Department of Planning and Environment

Our ref: DOC23/111195
Your Ref: SSD-45121248

Subject: EHG Advice on the Environmental Impact Statement for the Neringah Senior Housing and Hospital (SSD-45121248)

Tree Impact and Protection Plan Legend

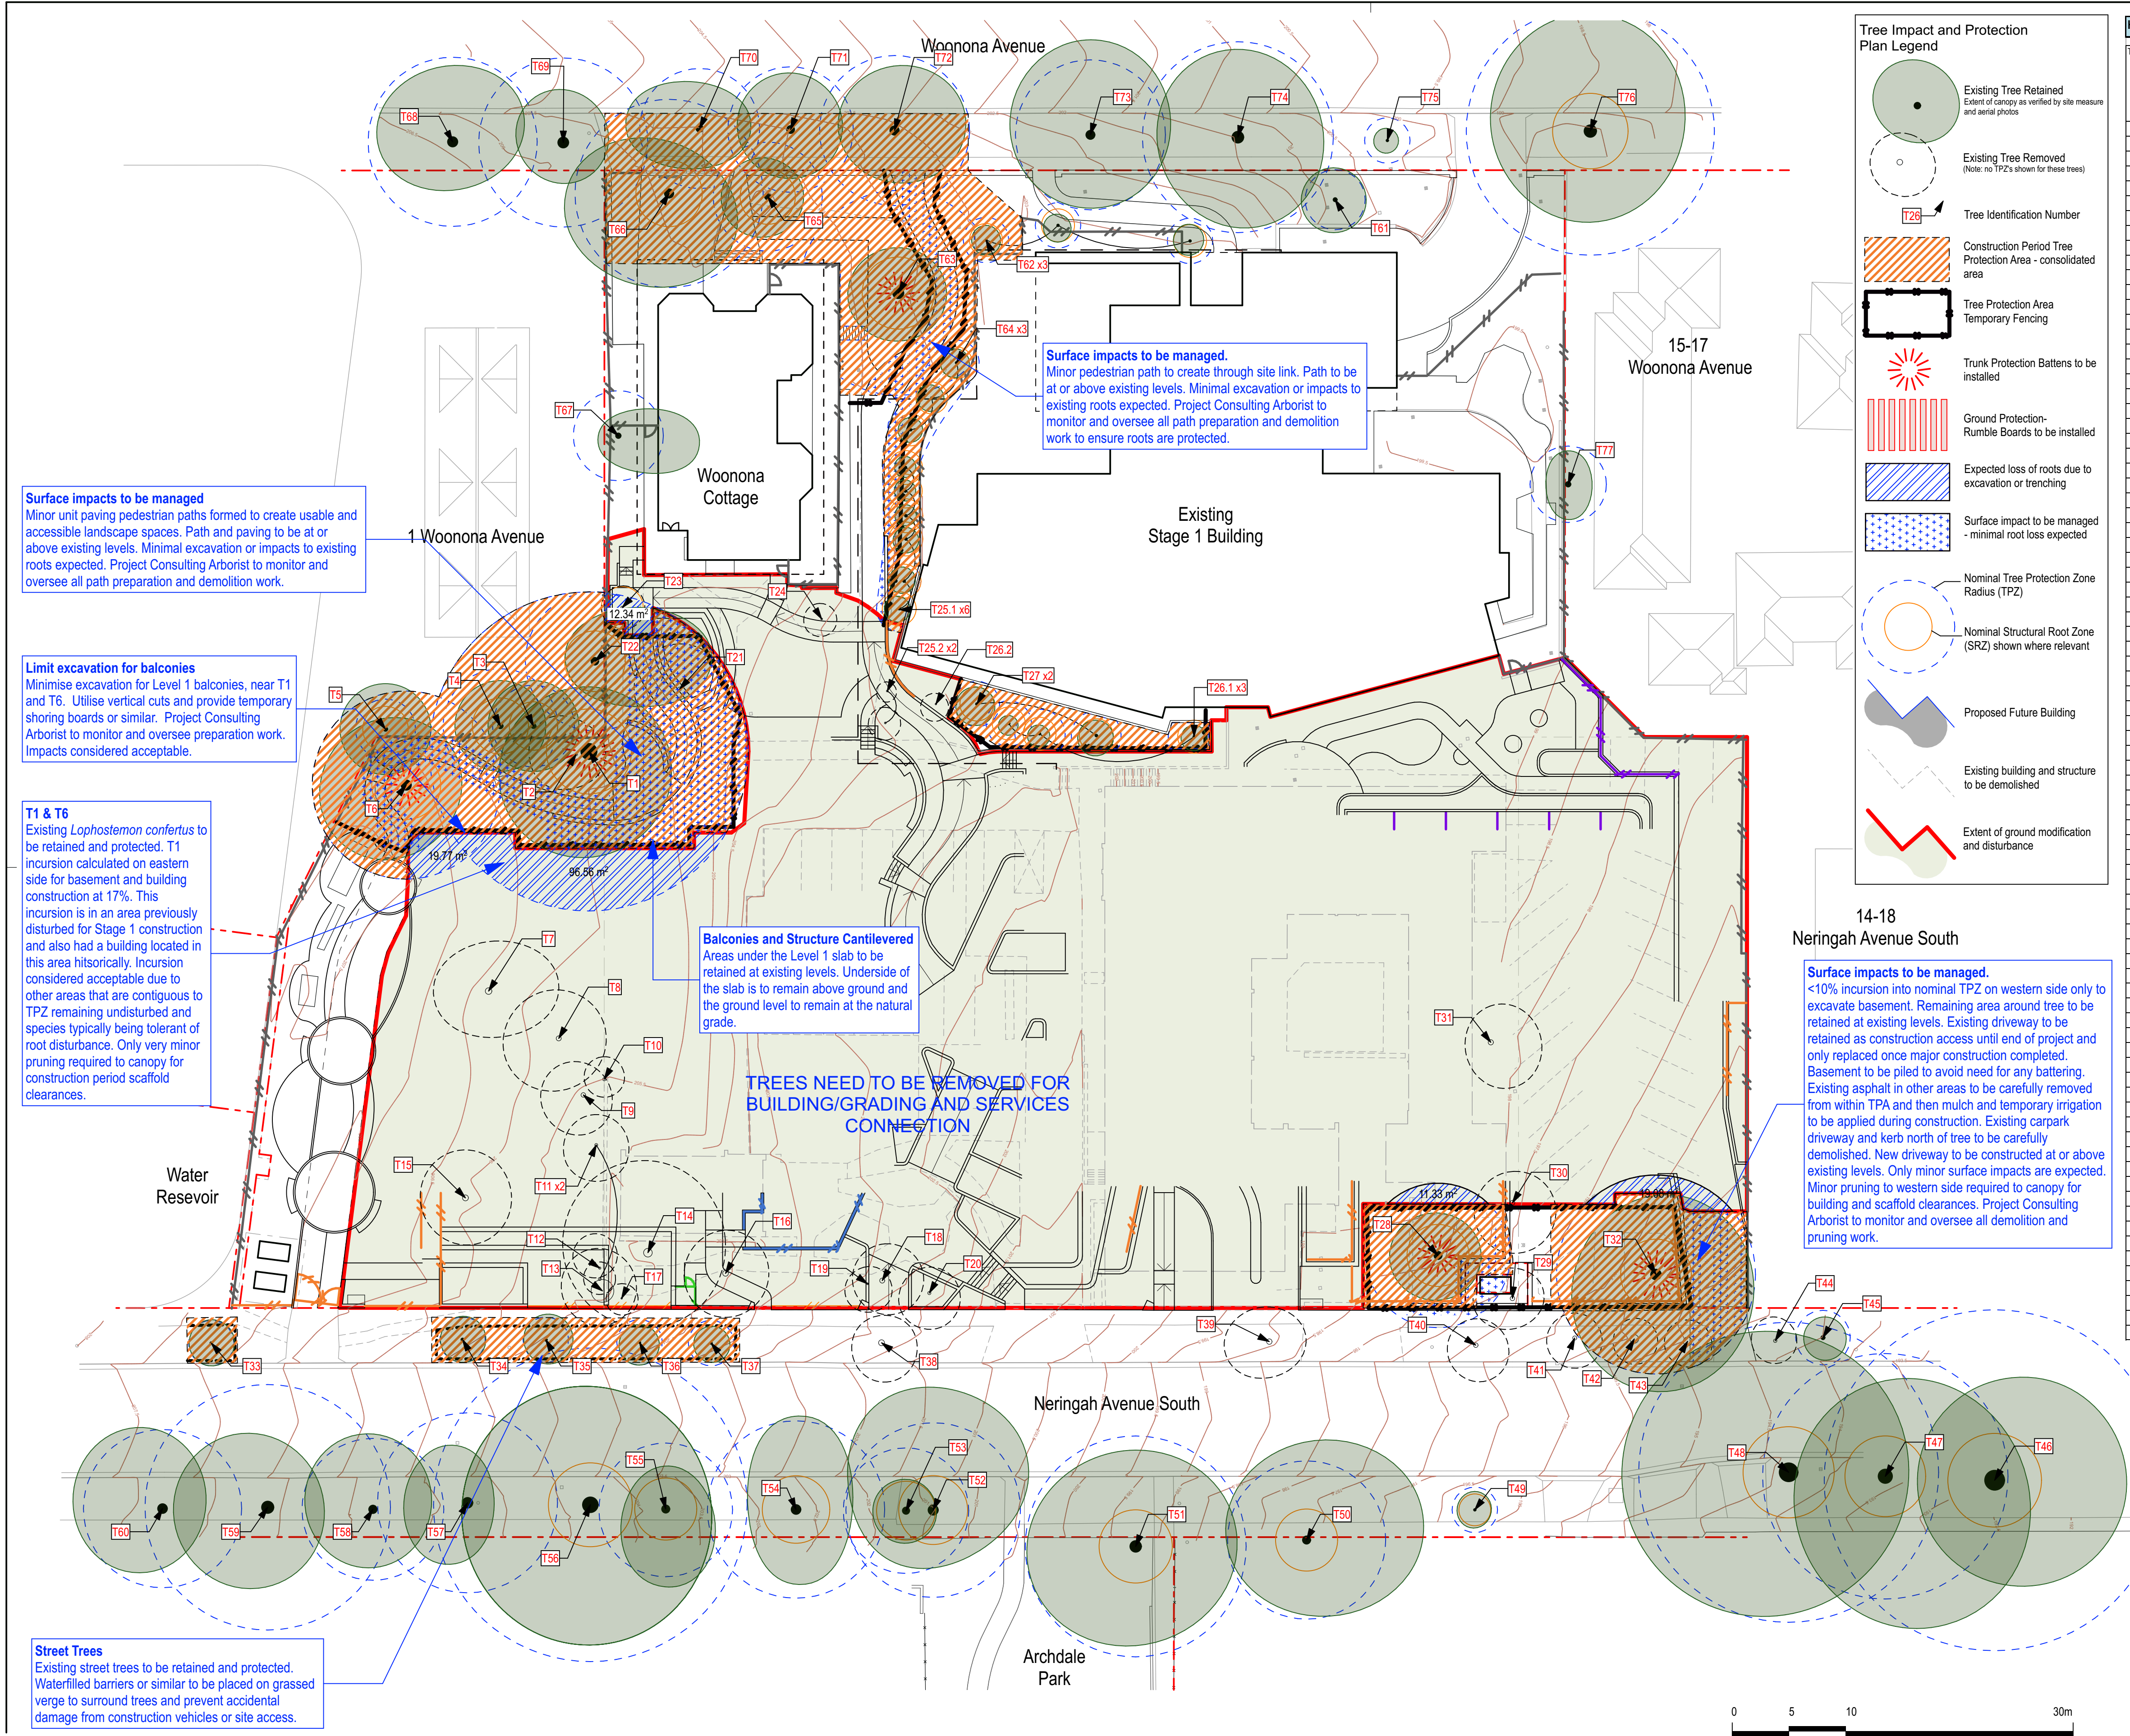
On 28 October 2023, EHG issued its determination to the DPE Planning Group that the proposed development is not likely to have a significant impact on biodiversity values and that the application does not need to be accompanied by a BDAR. This decision was made on the basis that the following recommendations were implemented on the site for the Sydney Red Gum (*Angophora costata*) identified as Tree 32 on the submitted Arboricultural Plans:

- That a Tree Protection Zone (TPZ) of 9m is established prior to the commencement of works
- There is no regrading or excavation along the existing proposed driveway within a 9m setback from the street boundary and for the remainder of the TPZ to the east of the building.
- There is only very minor reconfiguration of the current driveway width/extent.
- Tree sensitive construction measures are used for the new driveway, and are typically at, or above, the existing levels.
- The proposed general tree protection measures are strictly adhered to, during construction, in accordance with the Australian Standard AS4790-2009 Protection of trees on development sites.
- No major services, such as stormwater, are run from the building or along this boundary and out to the street in the vicinity of this tree.

In this regard, the BDAR Waiver Request Report specifically advised that provided the above recommendations are adhered to, impacts to native vegetation within the study area are considered unlikely to occur during or after construction works. In reviewing the submitted EIS documentation EHG notes that not all the above mitigation measures will in fact be implemented, further, EHG notes that there are additional proposed impacts to the TPZ of Tree 32 that were not assessed as part of the BDAR Waiver process. In this regard:

- a TPZ of 9m will not be established for the protection of Tree 32.
- an incursion of 8% to the TPZ of Tree 32 is proposed in association with the construction of the proposed northern building and its basements levels.
- The general tree protection measures are not being strictly adhered to, during construction, in accordance with Australian Standard AS4790-2009 Protection of Tree on development Sites (i.e., keeping construction activities out of TPZs). In this regard, EHG notes that the submitted Civil Plans and Arboricultural Plans indicate that access to the site during (and post) construction will be provided via the existing driveway that is located within the TPZ of Tree 32 with no other construction access currently being identified. Such an approach could

- Existing and cumulative incursions to the TPZ of Tree 32 do not appear to have been considered.
- Impacts associated with the construction footprint on the TPZ of Tree 32 (installation of scaffolding etc) do not appear to have been considered.

- Recommendations for the proposed removal of three trees within the TPZ of Tree 32 have not been specified within the AIA to minimise the impacts of such works.

- No specific excavation or construction methods have been specified for proposed works within the TPZ of Tree 32. This is even though there is a high risk that such works could significantly sever tree roots.

- Pruning requirements for Tree 32 have not been specified.

Based on the above matters, EHG considers that it has not been demonstrated that Tree 32 can in fact be retained post development. In this regard, EHG advises that the proposed development should be redesigned to remove access to the site through the TPZ of Tree 32 during both the construction and operational phase of the development and that the TPZ of Tree 32 within the subject site should be reinstated to a naturalised state. Consideration should also be given to reducing the extent of the proposed 8% incursion to the TPZ of Tree 32 associated with the proposed northern building.
